Engineers Comments Regarding Surface Water Drainage

Application Reference:	FP/10/26/DOC	Reviewer Reference:	ADC/EXT5/AF
Planning Officer:	Daniel Vick	Date of Review:	29/09/2026
Site Name:	Land off Stanhorn Grove Felpham PO22 8FA		
Application Description:	Approval of details reserved by condition under FP/32/25/S73 relating to conditions 6 & 7 - drainage.		
Assessment Number:	5

Application Reference: FP/10/26/DOC Site Name: Land off Stanhorn Grove Felpham PO22 8FA	Initial Issue Date: 16/02/2026 Issue Date: 29/09/2026 Reviewer Reference: ADC/EXT5/AF
--	--

SCALE	DATE	
1:250 @ A1	Jun 2025	
DRAWN BY	CHECKED BY	
JF	GB	
JOB NO.	DWG NO.	REV
0043	SL(5)500	Q

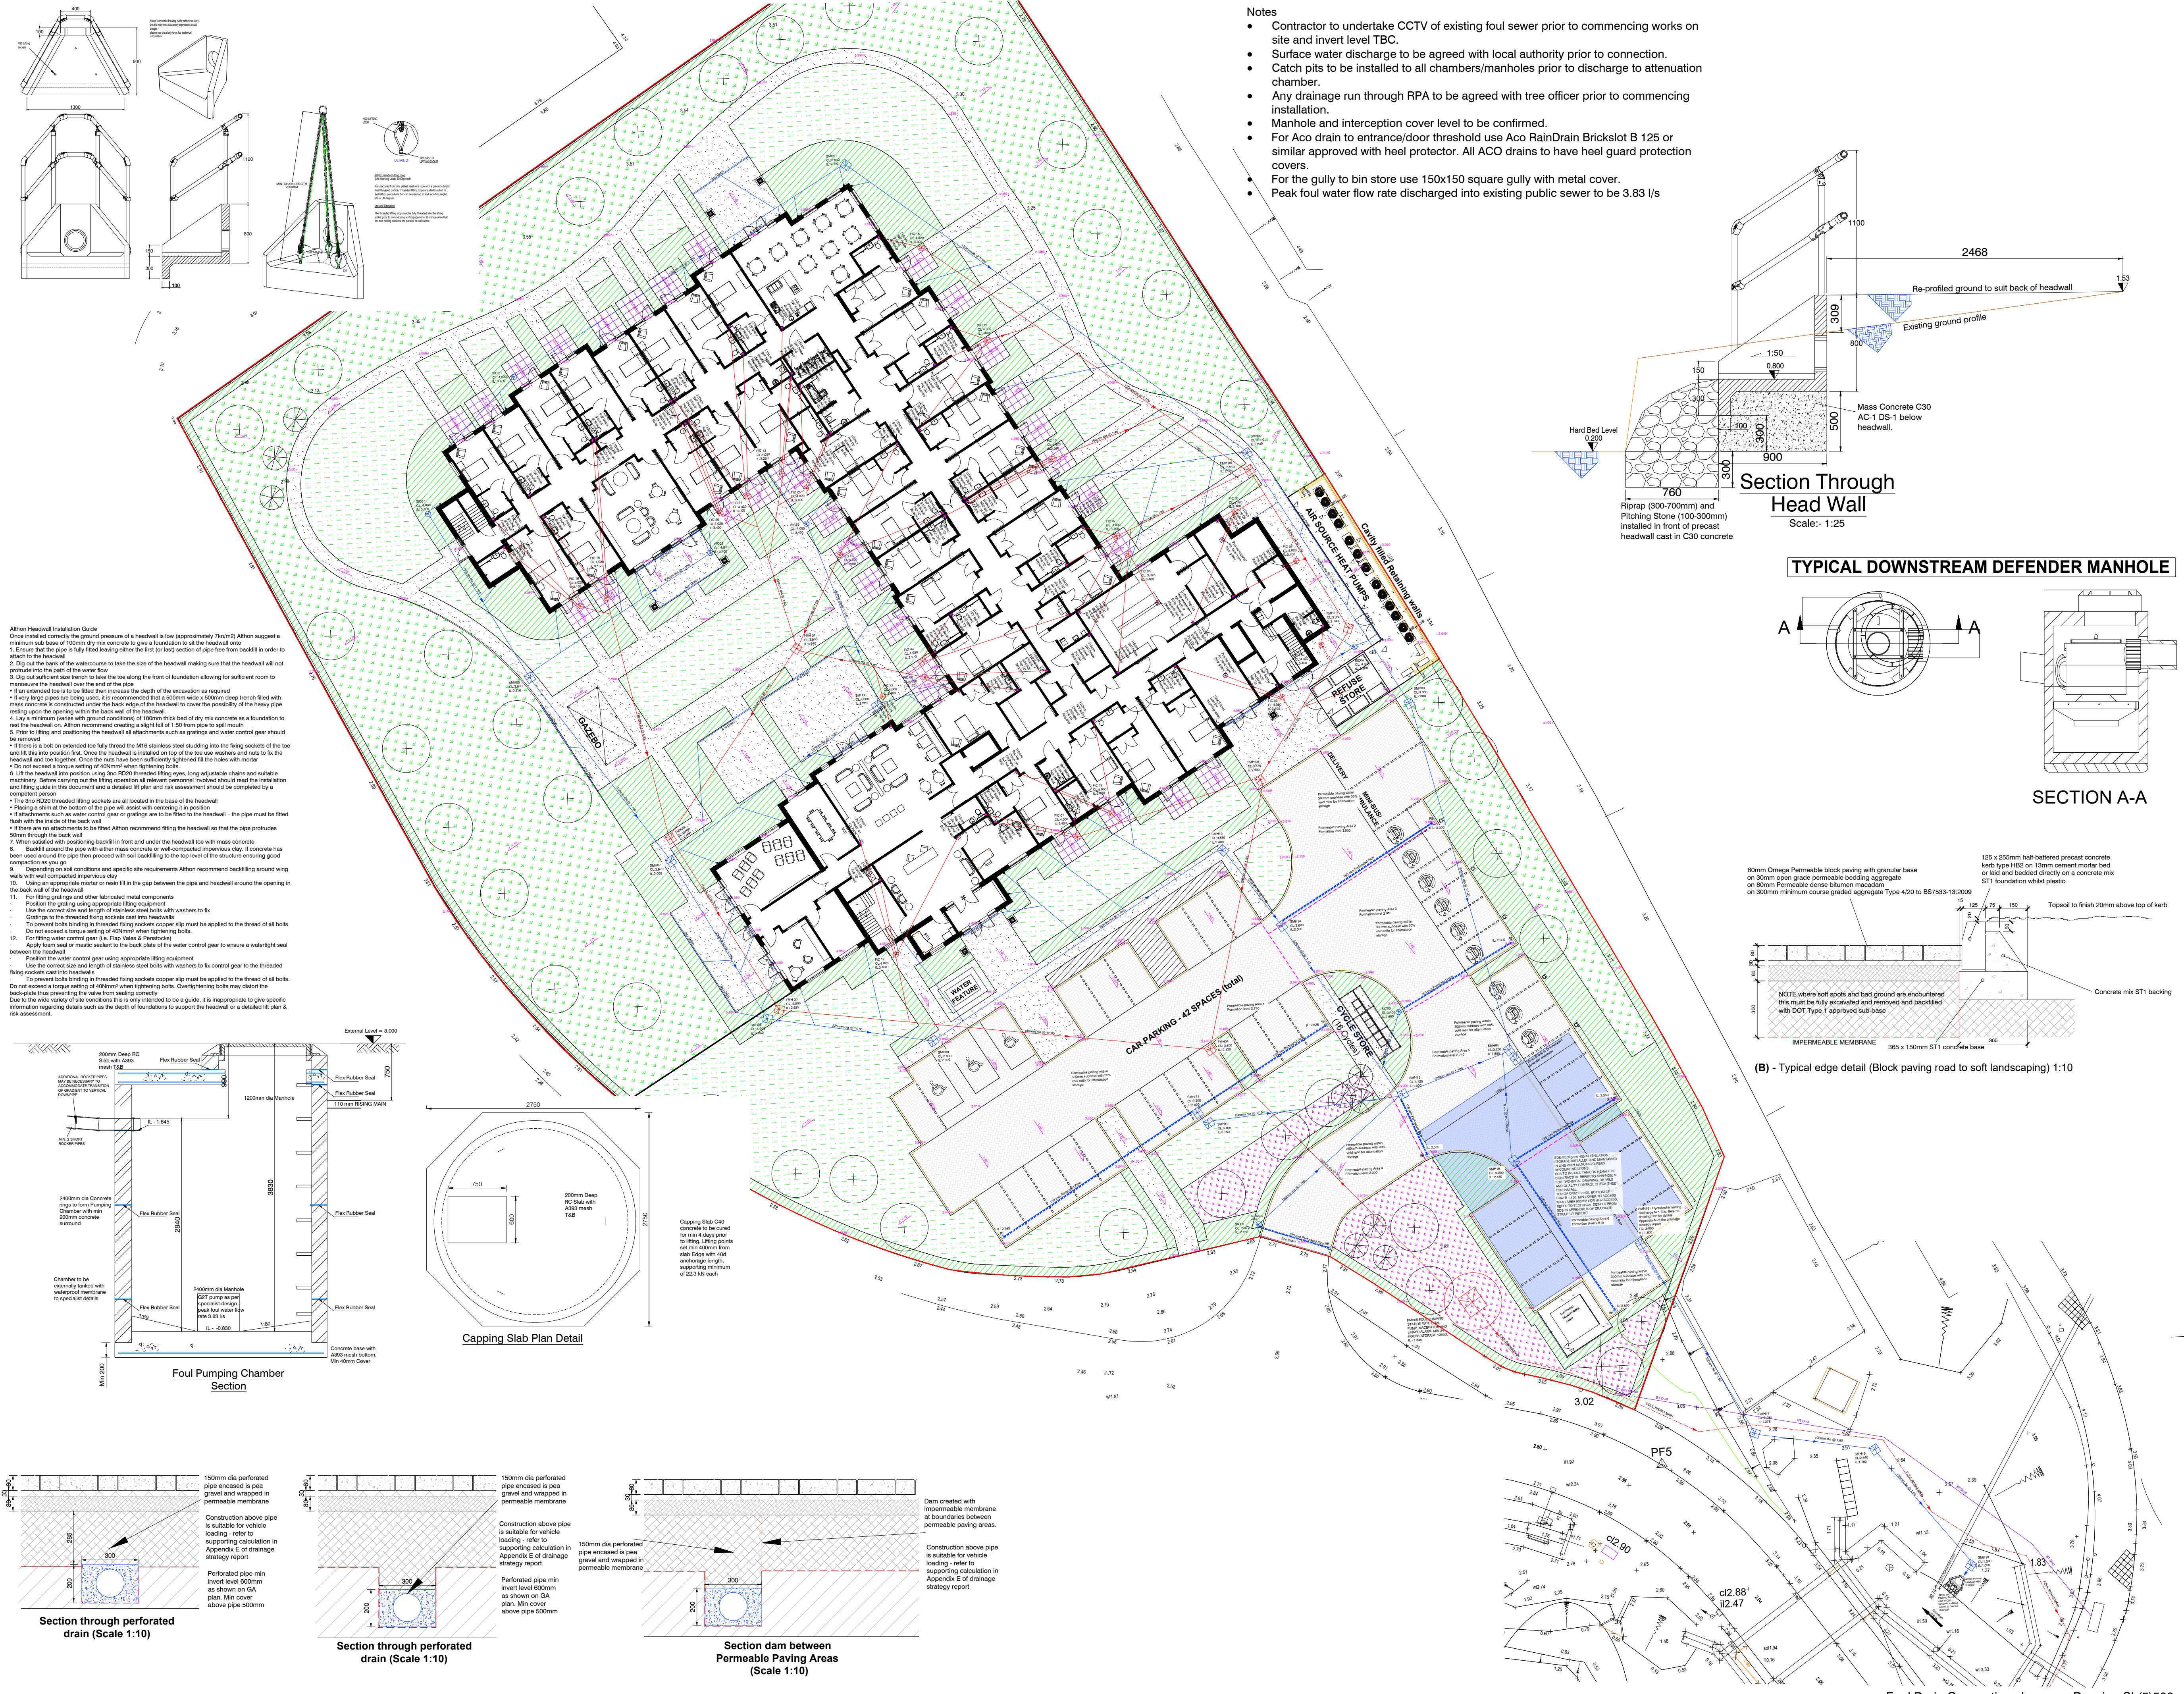
consent, in order to discharge the condition. https://www1.arun.gov.uk/land-drainage-byelaw-consent ADC Drainage Comments 15/06/2026 This is now contained within the revised permeable paving would fill to the modelled levels without overtopping at the low point of the combined construction				
4 (Formally 11)	ADC Drainage Comments 16/02/2026 The drained area is less than the area used to calculate greenfield runoff and should be the same. There is guidance on the ADC website which includes requirements for calculation of greenfield runoff and assessment of drained areas. ADC Drainage Comments 15/06/2026 This is now correct, comment closed				
5 (Formally 12)	ADC Drainage Comments 15/06/2026 Additional comment: There are a number of permeable paving compartments which are not	None ADC Drainage Comments 27/07/2026	Drawing 502L'Drianage Layout – Foul Connection' and 500P 'Drainage Layout' within Appendix F of the submitted report (Drainage Strategy Rev D) is	The layout of the permeable paving compartments is clarified on drawing 500Q. Comment closed.

physically segregated. They are not defined in plan and it is difficult to audit the areas. The overflow level in the plans appears to be 2.78m AOD. The modelled compartments all have higher exceedance level and fill to higher levels during the design storm, some clarification is required to confirm that the permeable paving would fill to the modelled levels without overtopping at the low point of the combined construction.	It is not clear how this comment has been addressed. Some commentary or response from the designer should be provided. Designer Response 31/07/2026 and 20/08/2026 The permeable paving zones are indicated on the drainage layout drawing SL500(P) within Appendix F of the report. The zones are highlighted with an orange dotted line and the reference numbers are consistent between this drawing and the drainage calculations in Appendix E. A dam is created between the paving zones using the impermeable membrane like the image below. We will add this detail to the drawing for clarity.	unchanged since our previous comments.
